Your Ref: OWPC18851
Our Ref: AW/129/18/HH
Please ask for:
Mr R Castro-Parker

14th June 2018

Loft conversion & single storey side extension.
20 Aldwick Gardens Aldwick

Proposed West Elevation

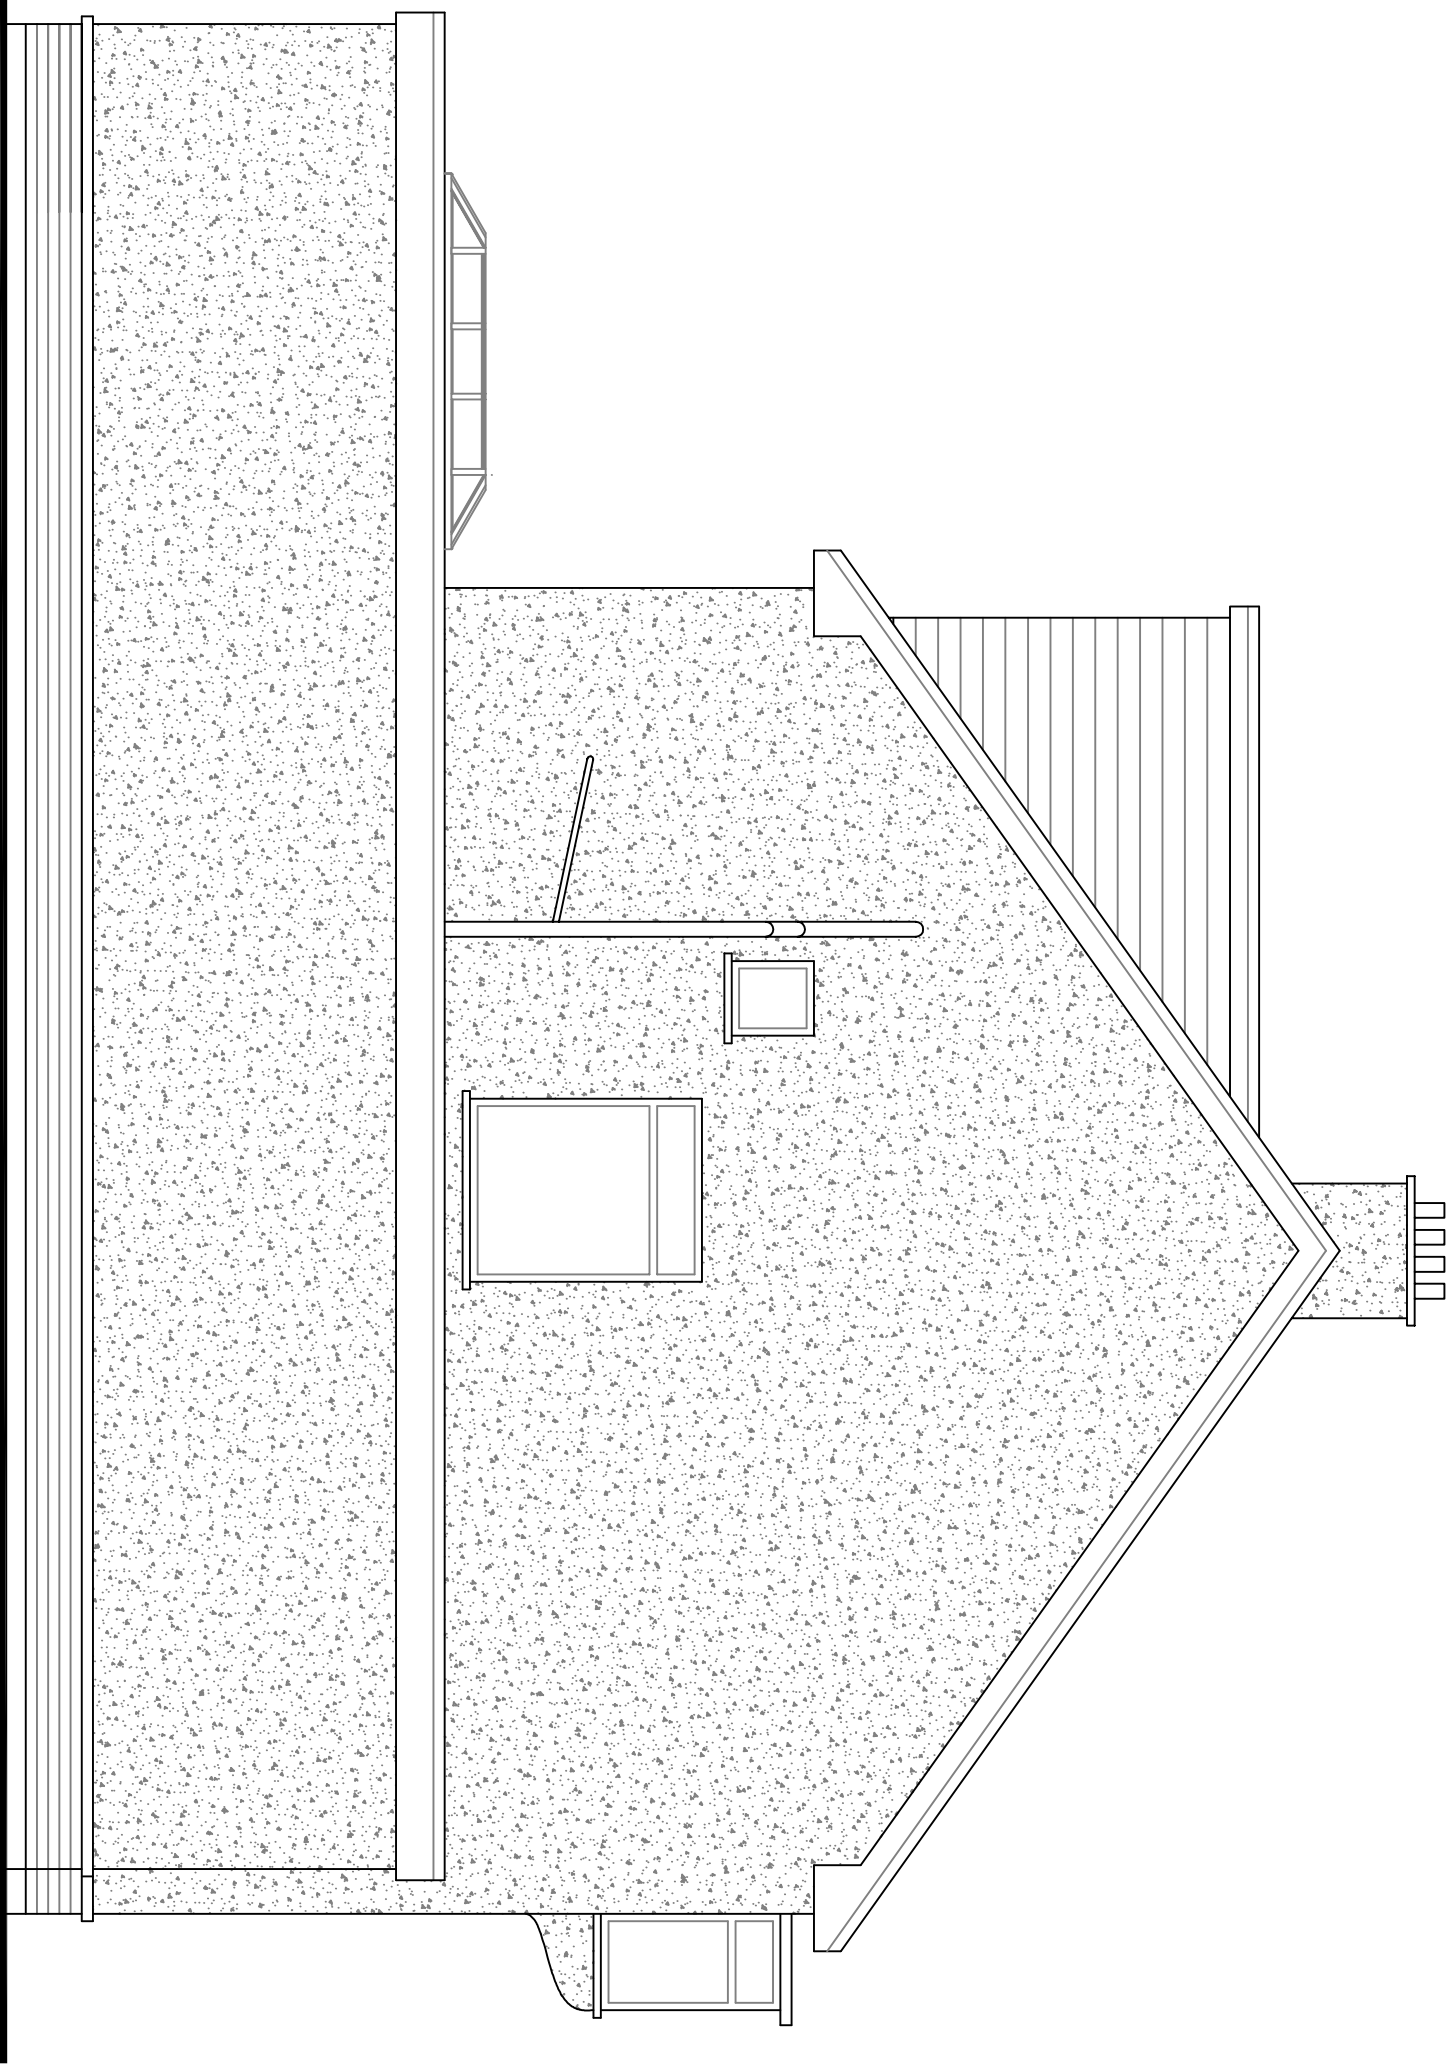
Members strongly opposed the application on the grounds that the proposed conversion and extension does not sympathetically relate to and is not visually integrated with the existing building in siting, design, form, scale and materials. Therefore Members agreed that the application is in direct conflict with Policy Dev 19 (i) of the Arun District Local Plan 2003
